### North Mercer Island Interceptor and Enatai Interceptor Upgrade Project – Response to City of Mercer Island Request for Information (PAE19-001, CAO19-020, and SHL19-019)

This letter is in response to your request for information on the land use permit application materials for the North Mercer Island Interceptor and Enatai Interceptor Upgrade Project (NME Project) on Mercer Island, Washington. This letter addresses comments from the City of Mercer Island (Mercer Island) Community Planning and Development Department and two third party reviewers: (1) Wood Environment & Infrastructure Solutions, Inc. (Wood) and (2) Environmental Science Associates (ESA). In addition, there was an update to the proposed trash rack located on Mercer Island right-of-way adjacent to the North Mercer Pump Station (NMPS), updates to the landscape restoration and impact values, and some minor changes to the proposed schedule.

Enclosure(s): Sheet T-C101

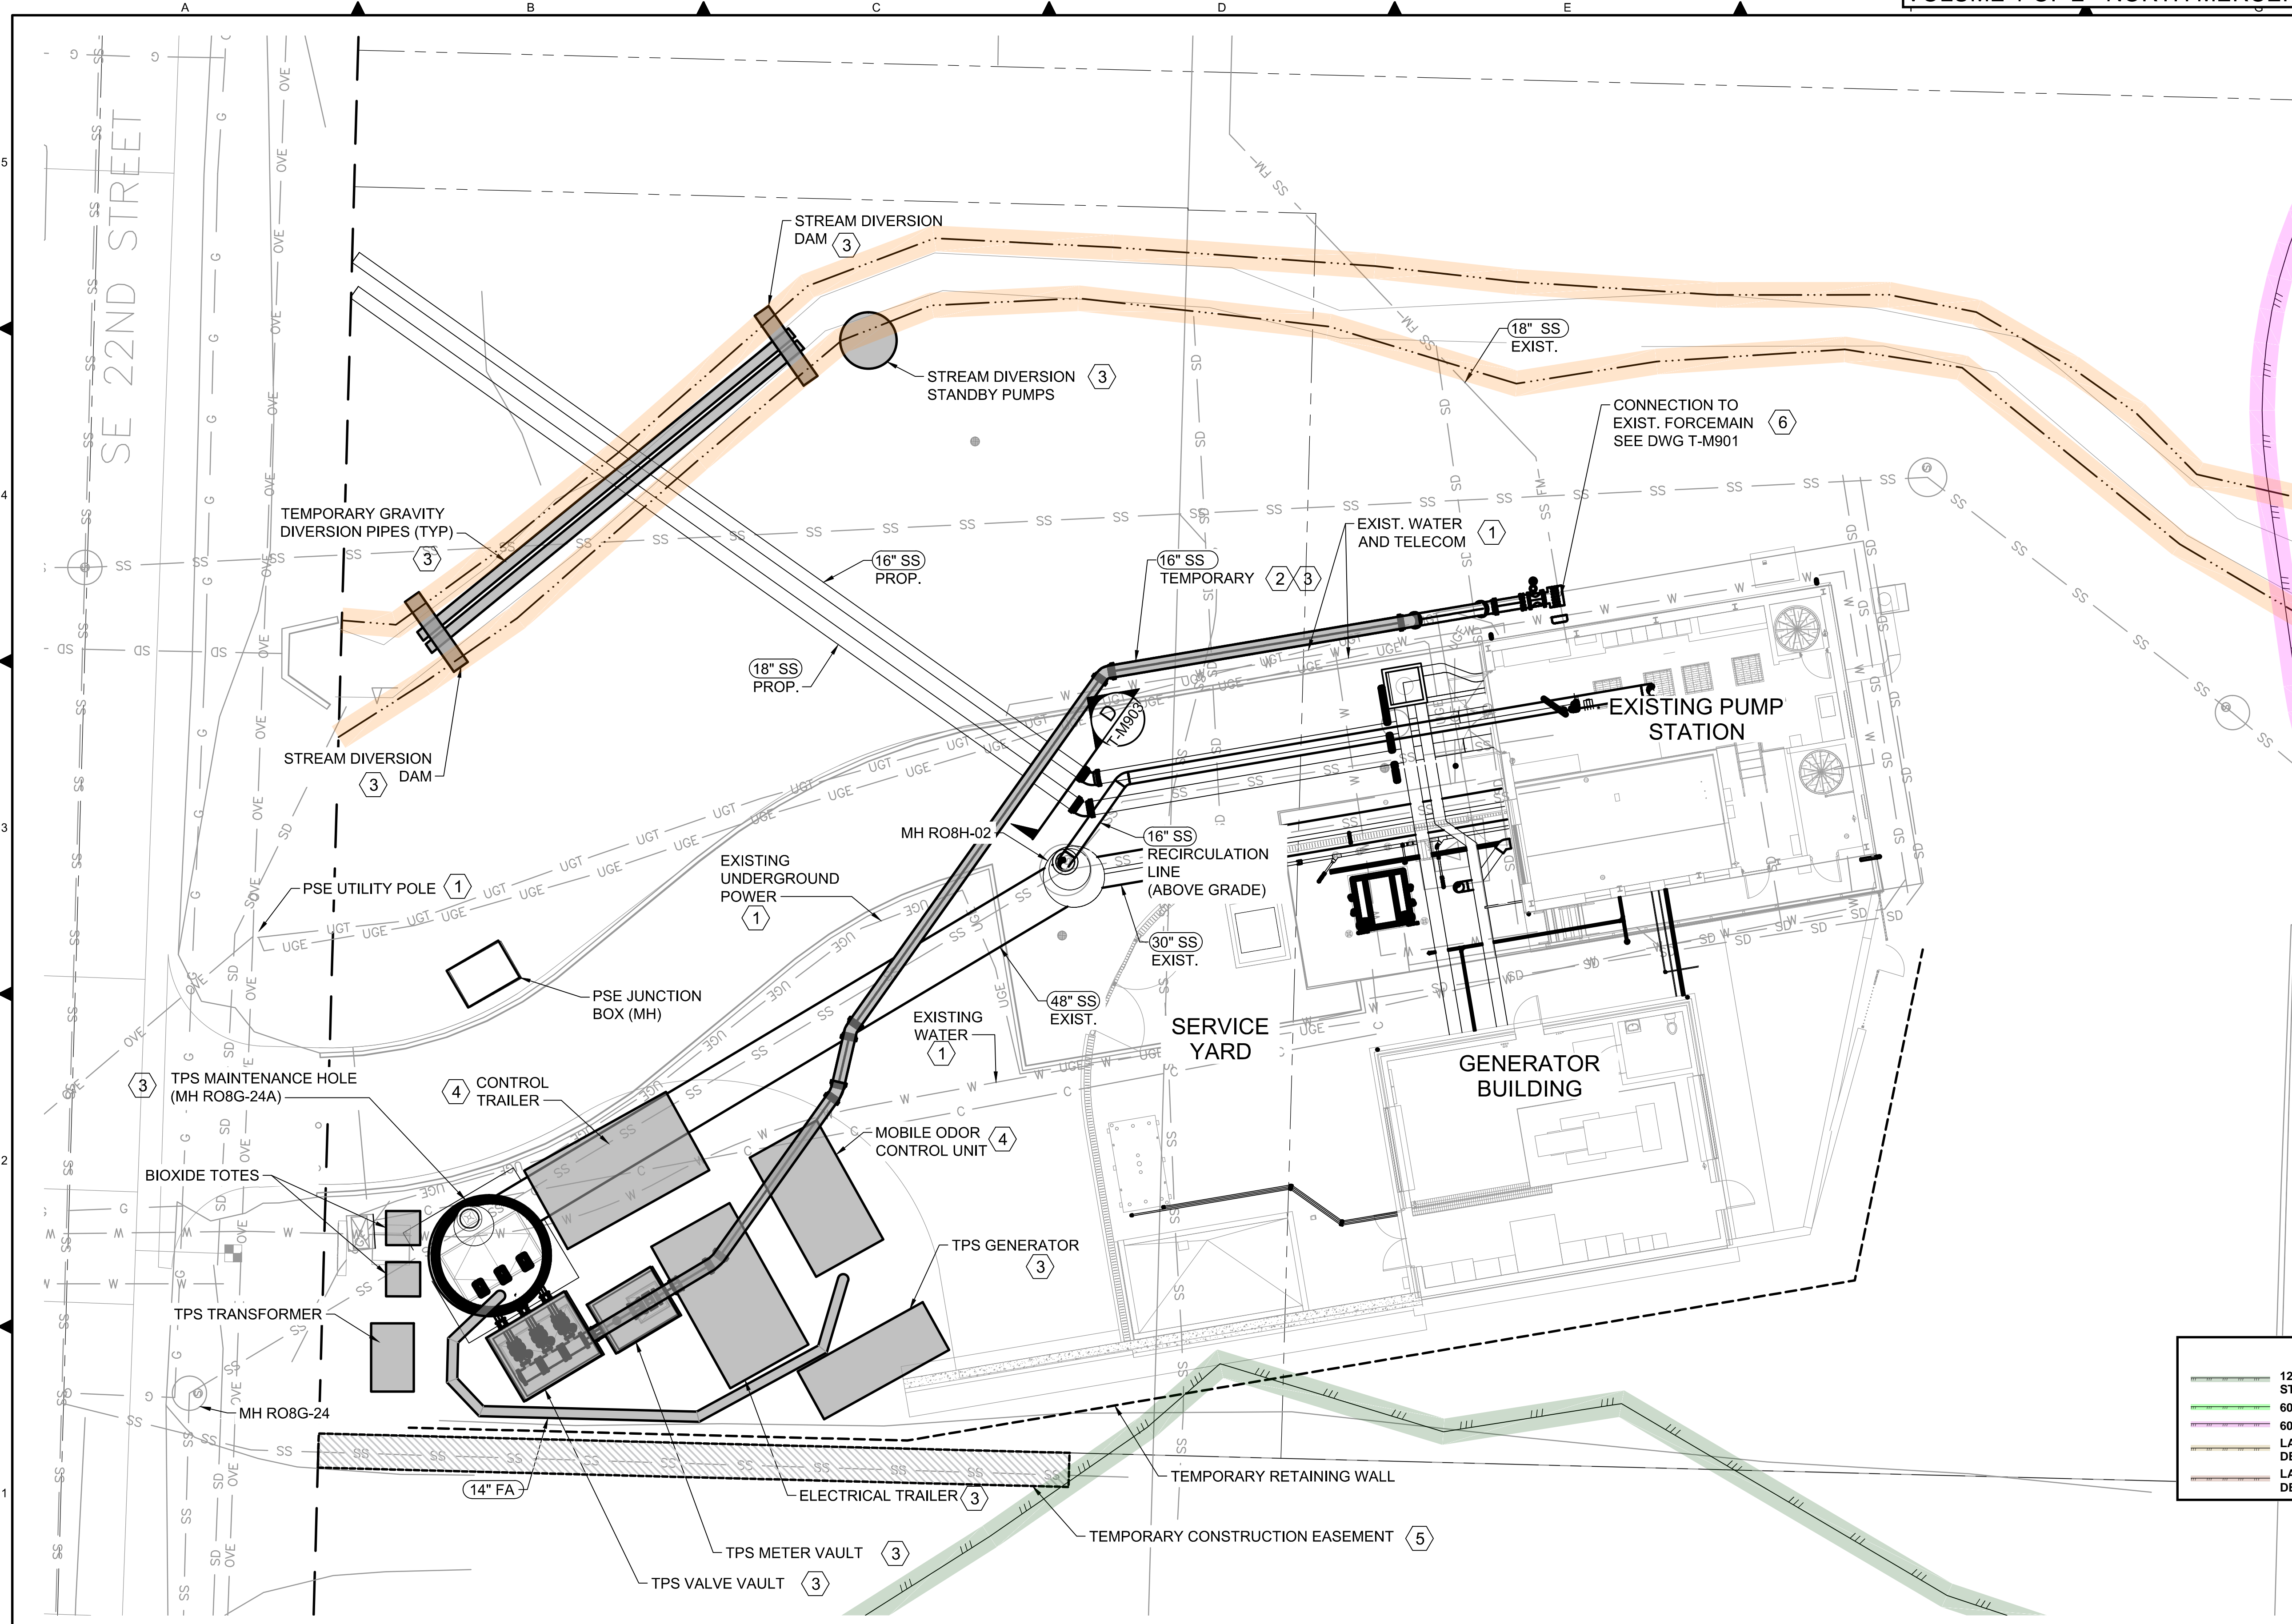
**Mercer Island Comment:** Please provide information about the height of the proposed temporary improvements along SE 22<sup>nd</sup> Street, including the TPS [Temporary Pump Station] transformer, bioxide totes, temporary retaining wall, and stream diversion dam and show compliance with MICC 19.02.020(C)(3).

**Response:** *The following provides the height of the proposed temporary improvements along SE 22<sup>nd</sup> Street (as shown on Volume 1 Drawing, T-C101) and demonstrates compliance with MICC 19.02.020(C)(3):*

- *Temporary Fence: The North Mercer Pump Station site will be temporarily fenced during construction. The fence will be six feet tall and will have a vinyl banner attached to limit the view into the site. Under MICC 19.02.050(E) (as referenced in MICC 19.02.020(C)(3)(c)), the height of the fence will not exceed the maximum height of 72 inches.*

- *Temporary Pump Station (TPS): Within the fenced area will be the temporary pump station (TPS), which will set less than a foot above grade.*
- *Electrical and Power Systems: Within the fence will be power systems and electrical trailers at about 12 feet tall, and a standby generator set at about 14 feet tall.*

- *Temporary Odor Control Systems: A mobile odor control unit at about 8 feet tall shall provide odor control for the TPS during construction, and bioxide chemical totes at about three feet tall will provide chemical injection to reduce sulfides in the system.*

- *Temporary Electrical Transformer: Outside the fence along the street will be a temporary electrical transformer up to about six feet tall.*
- *Temporary Retaining Wall: Along the western property boundary, a temporary retaining wall will extend from zero feet tall near SE 22<sup>nd</sup> Street to about maximum of about 8 feet tall adjacent to the planned generator building. Under MICC 19.02.050(E), for Cut Slopes (as referenced in MICC 19.02.020(C)(3)(c)), the height of the retaining wall shall not exceed the maximum height of 144 inches.*

- *Temporary Dam: During the installation of sewer force mains across the existing stream, a temporary dam will be built across the stream to allow for the trenching work to progress in dry conditions. This will be up to about four feet high, but because it is set down into the creek, is well below the predominant site grade.*

*This temporary equipment is shown on PLAN Sheet Volume 1: T-C101.*
